CITY OF ALBUQUERQUE

November 21, 2016

Deepesh Kholwadwala, Dreamcatcher ABQ North, LLC: deepesh@suncapitolhotels.com
Fairfield Suites: 4875 Pan American Frwy NE

Re: Drainage Control Ordinance Violation

Fairfield Suites

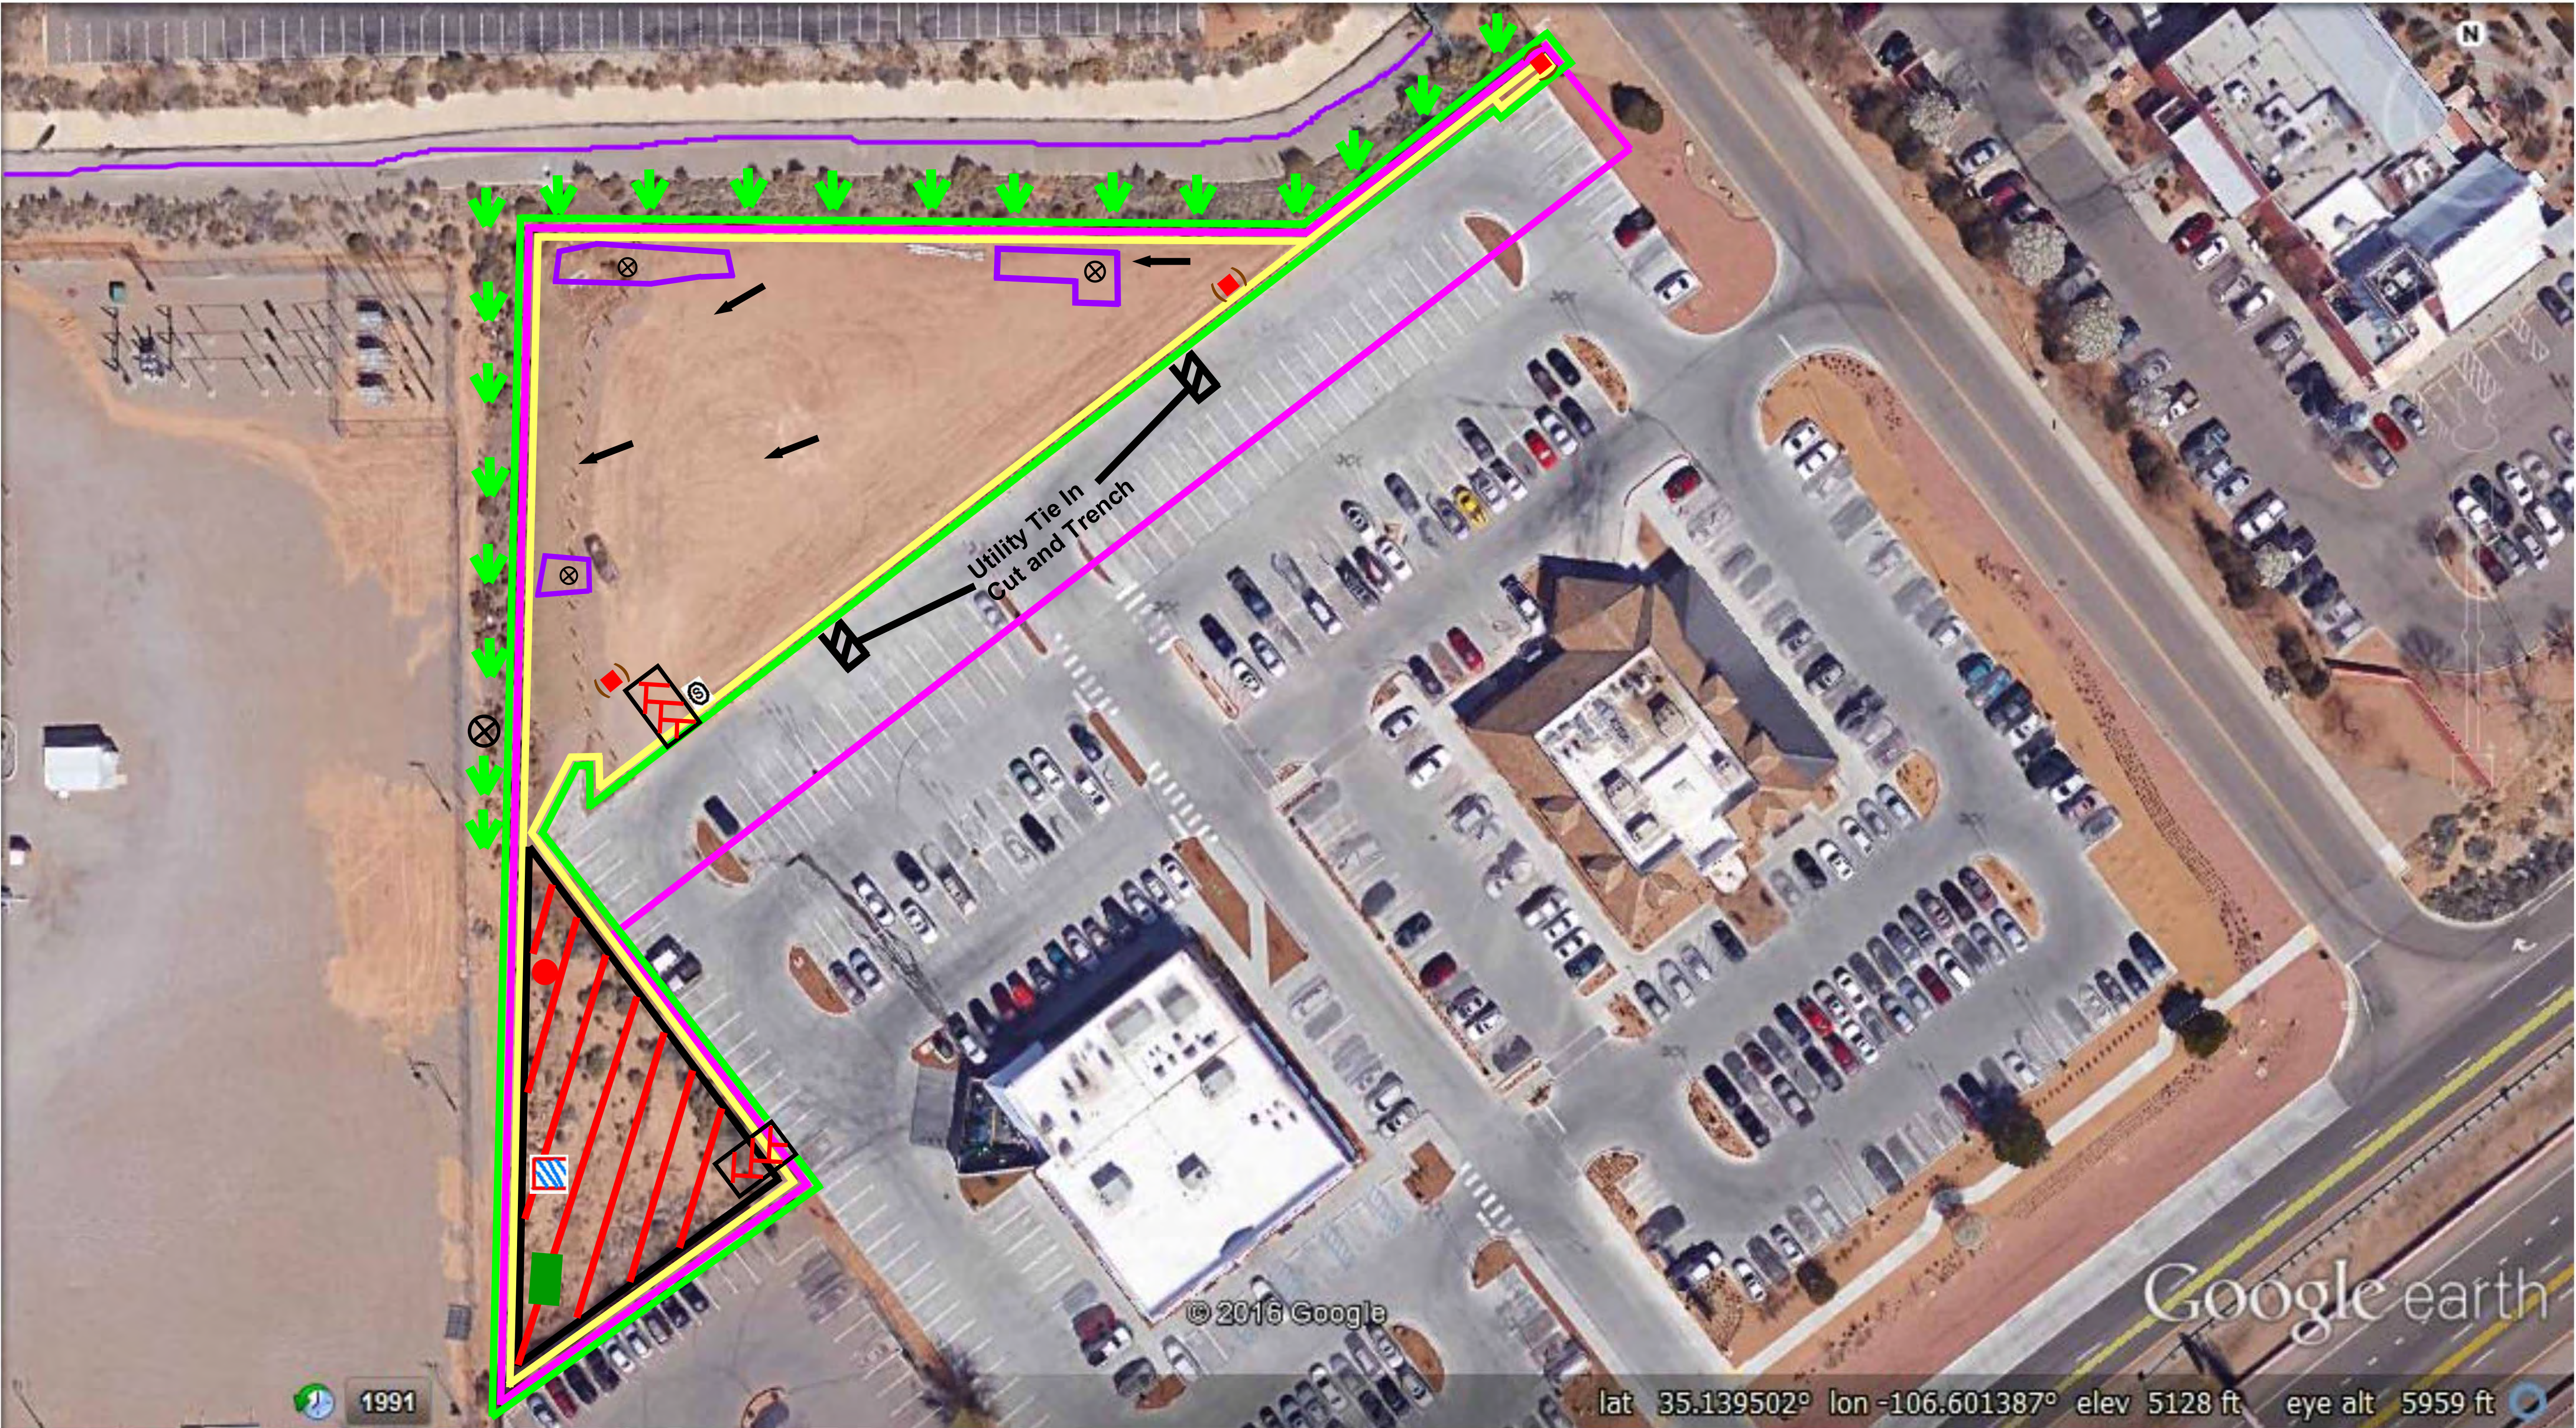
1. The inlet that drains Bubba's, Cheddar's and this site has been removed. The grades along the channel will divert flows in the PNM substation. Please contact your engineer to provide a temporary drainage solution until proposed inlets are installed and proper drainage is restored.

A site visit was performed this morning. The temporary drainage solution was not provided and drainage left the site and drained into the PNM substation. In addition, there is considerable erosion where the water comes off the parking lot.
